July 21, 2020

**Re: Letter of Intent in Support of Formation of Proposed Crossroads Metropolitan District Nos. 1 & 2**

# LOI V\_2 redlines.pdf Markup Summary 8-6-2020

## EXHIBIT A.1 – VICINITY MAP

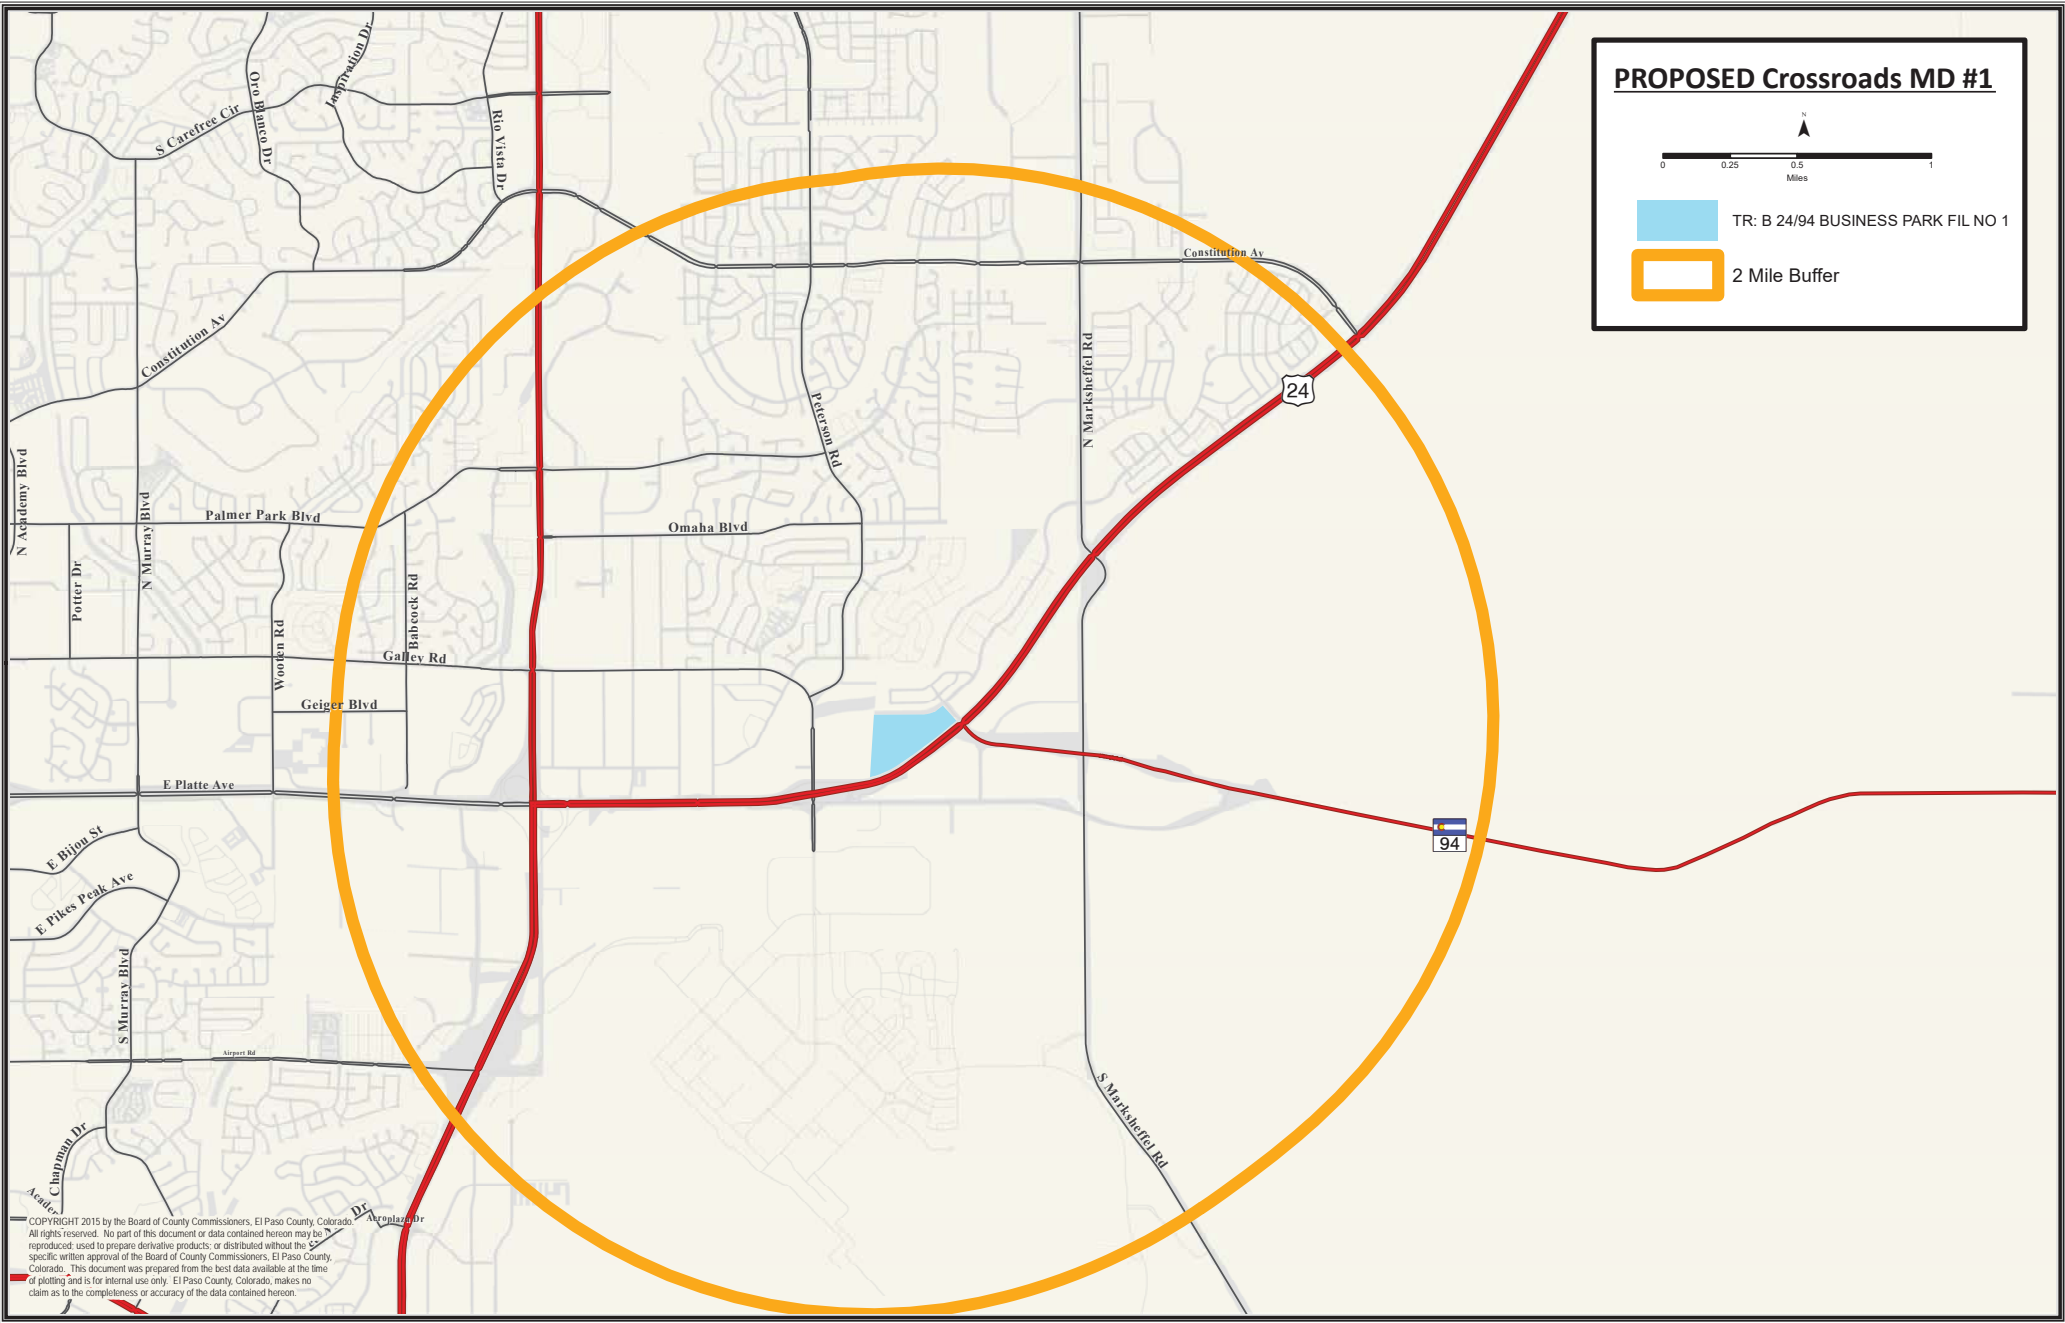
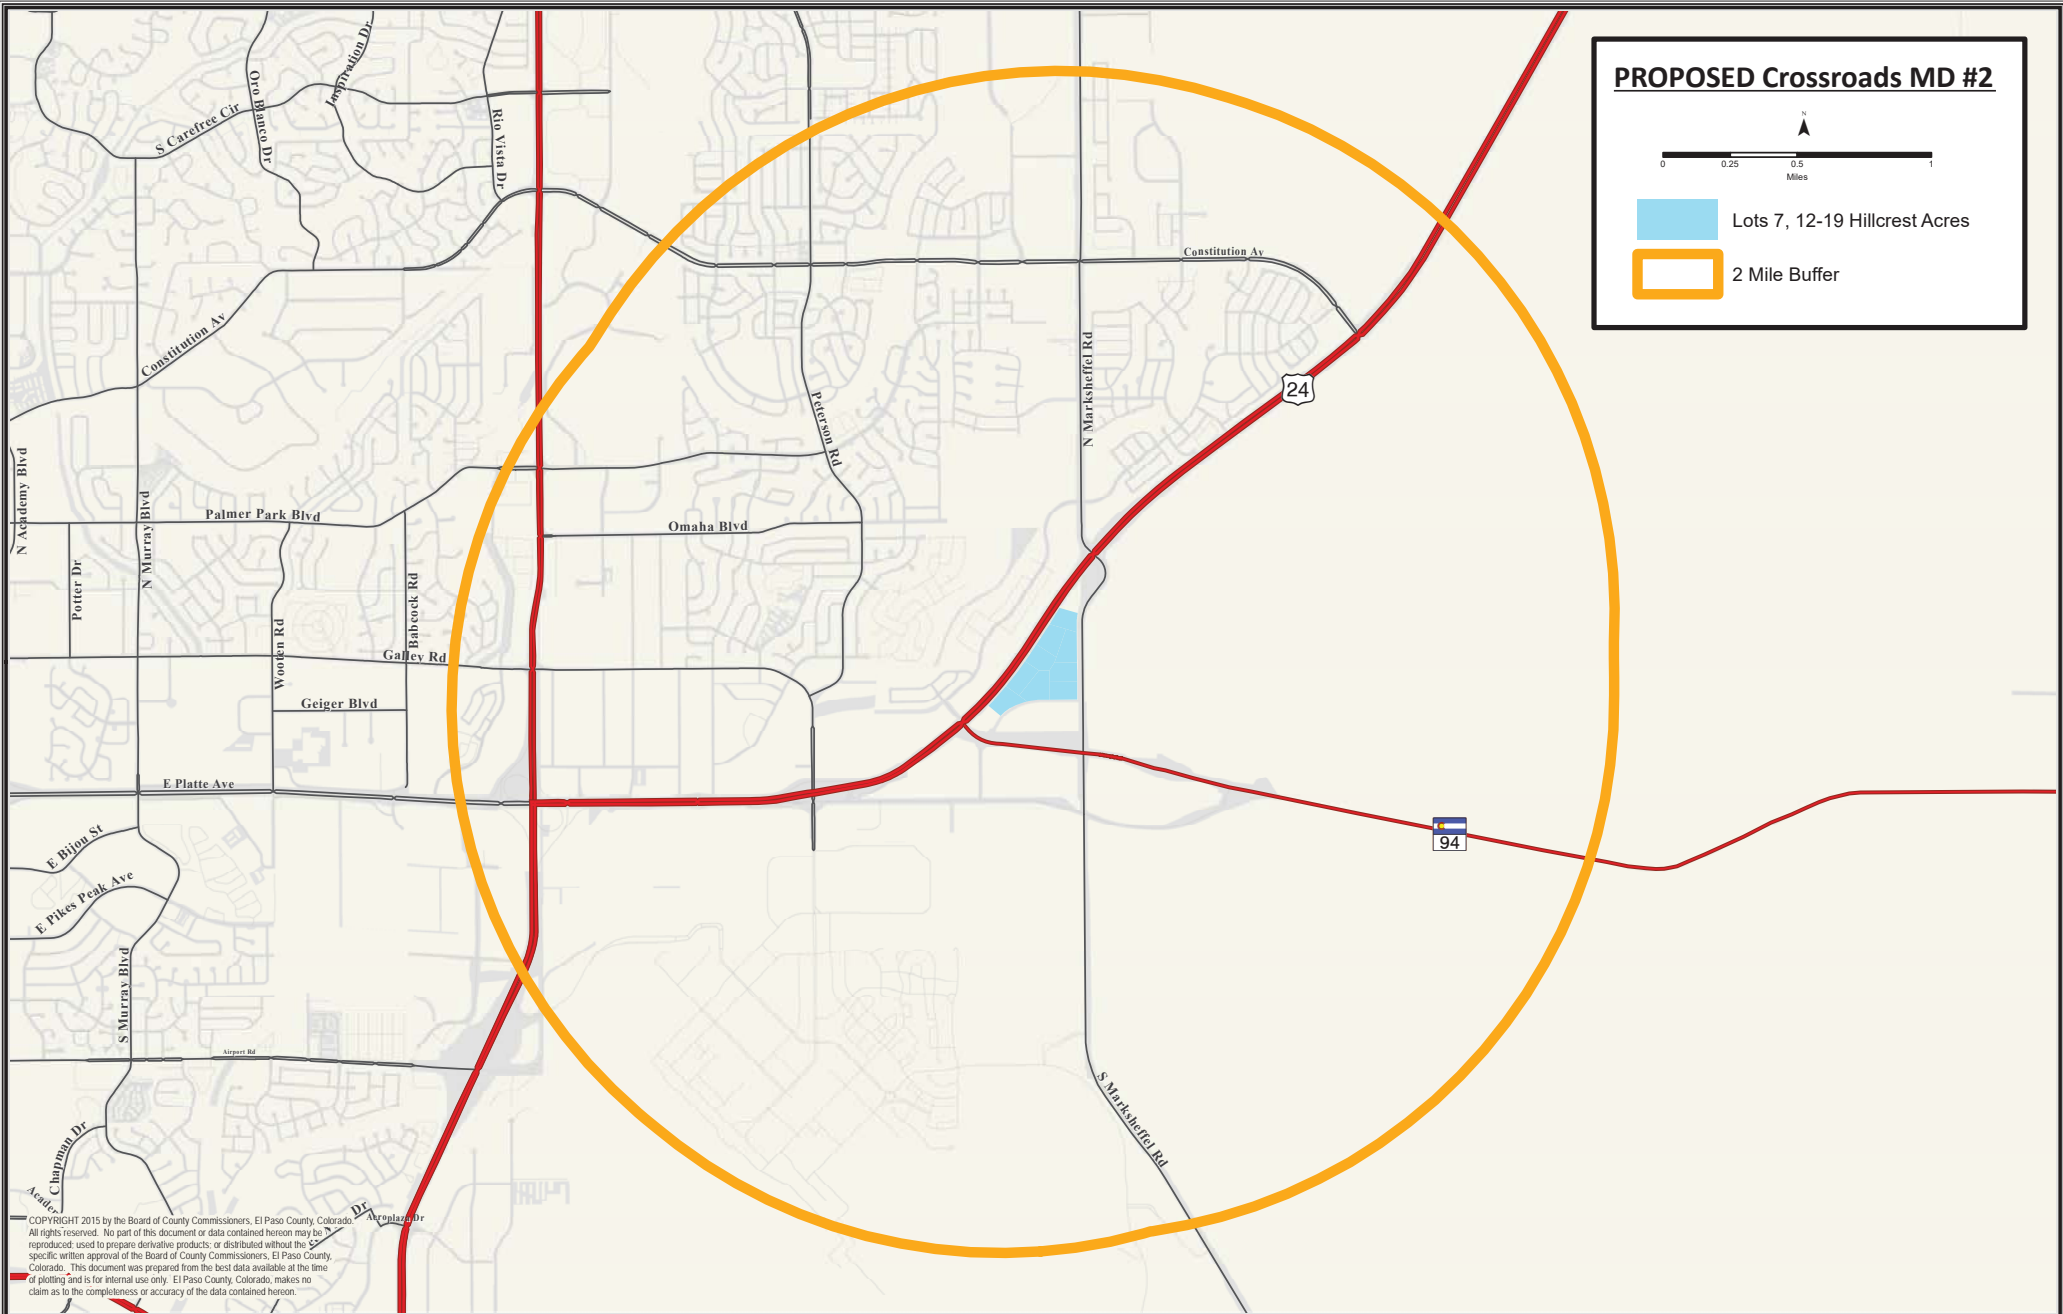
address the proposed district within City jurisdiction? or correct map and state that that is not the case.

I'm totally confused. The maps separate the Districts completely 1 is north of hwy 24 and 2 is south...?
